## 16-003 Bayside Anchor - Engineering Change

I am writing to inform you that we have made an engineering change to the original design for Bayside Anchor. We have removed two fire dampers - one in the dryer fan exhaust duct, and one in the dryer make-up fan duct. (Please see attached MSK-14). Per the manufacturer, fire dampers are not allowed in the exhaust duct of their dryer exhaust fan.

MSK-14
DRAWING NO.

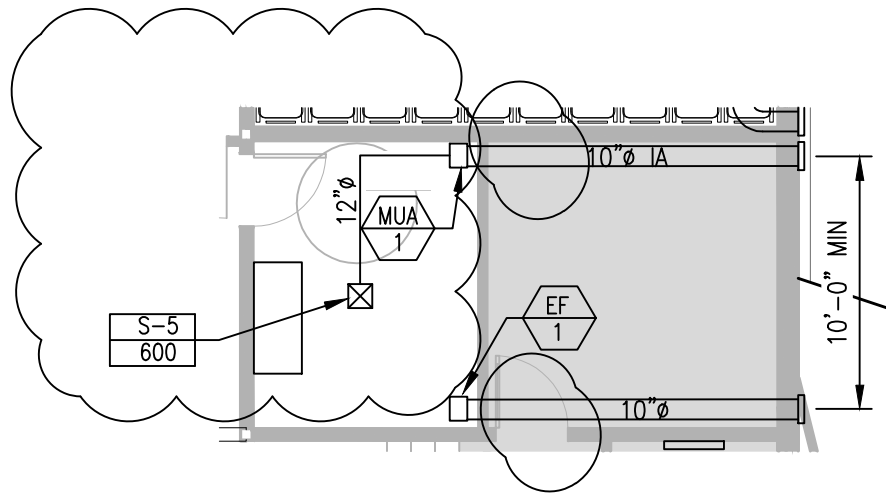
Upon further code study, we removed both fire dampers based on IBC Sec. 717.5.4 Fire Partitions, Exception 4, where:

“Such walls are penetrated by ducted HVAC systems, have a required *fire-resistance rating* of 1 hour or less, and are in buildings equipped throughout with an automatic sprinkler system”

In addition, these ducts will have to comply with Sec 717.1.2.

Thank you for sending this as built change, however, I am not able to find the code references you gave, are you using the 2009 IBC? Also, can you please clarify in your description that the MUA is for the laundry room, as opposed to the

1. For exception #3, can you please confirm that 26 gage thickness is continuous from the equipment to the outlet and inlet for the MUA?
2. Is the S-5 diffuser below the fire rated floor ceiling membrane, it does not show this on the M-100 plan.

717.5.4 Exception 4 becomes 716.5.2 Exception 3.

717.1.2 becomes 716.1.1

The make-up air is into the laundry room, but it is specifically making up the air the dryers are removing. The fans are tied together and the make-up air fan matches the flow of the dryer exhaust fan.

I will confirm (the ducts have not been installed yet), but we have been using 26 ga. duct throughout the building. The S-5 diffuser is below the fire-rated floor/ceiling membrane.

We have confirmed that the ductwork is 26 ga. minimum thickness.
